Consultation Response from KC Highways Development Management		
2025/90889 Former Combs Hostel, Hall Lane, Thornhill, Dewsbury, WF12 0PL		
Demolition of existing hostel and erection of residential development comprising 34 dwellings		
Date Responded: 16/04/26	Responding Officer: M Zenner	Responding Ref: 16-23NW/20

RECOMMENDATION: No objection in principle to the proposals but further information and amendments required.

Fig 3 Vehicle parked on the footway to the north of the Hall Lane junction with the B6117 (Google Earth image).

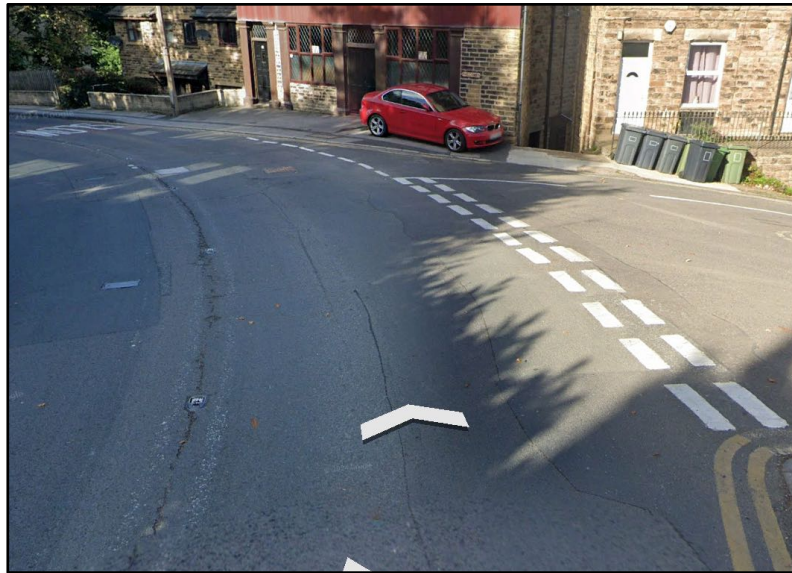
It is noted that condition was secured on the 2014 outline approval for a feasibility report to improve the sight lines at the junction of the B6117 and Hall Lane. The submitted Paragon Transport Statement reviews the existing access issues and suggests the provision of bollards on the footway adjacent to the the junction along The Combs and recommends the installation of warning signing on Church Lane / The Combs, which they feel would improve potential sight lines and raise awareness to the junction. Paragon also recommend that a Stage 1 Road Safety Audit is undertaken in relation to any improvements proposed in and around the Hall Lane / B6117 junction.

The LHA is concerned that the proposed bollards would need to be setback from the kerbline and could restrict the width of the footway for pedestrians. Furthermore, there are existing 'Reduce Speed Now'

signs alongside 'Slow' markings in advance of the junction already in place on the B6117 in either direction.

Highway Safety have been consulted on the improvements outlined in the Transport Statement and have advised that they do not feel the provision of additional signage is required. However, they have recommended that as the Hall Lane road surface is a poor condition and the double yellow lines are no longer visible that it would be beneficial for the applicant to resurface Hall Lane across the proposed site frontage upto the Hall Lane junction with The Combs and reinstall the linings and markings along the route.
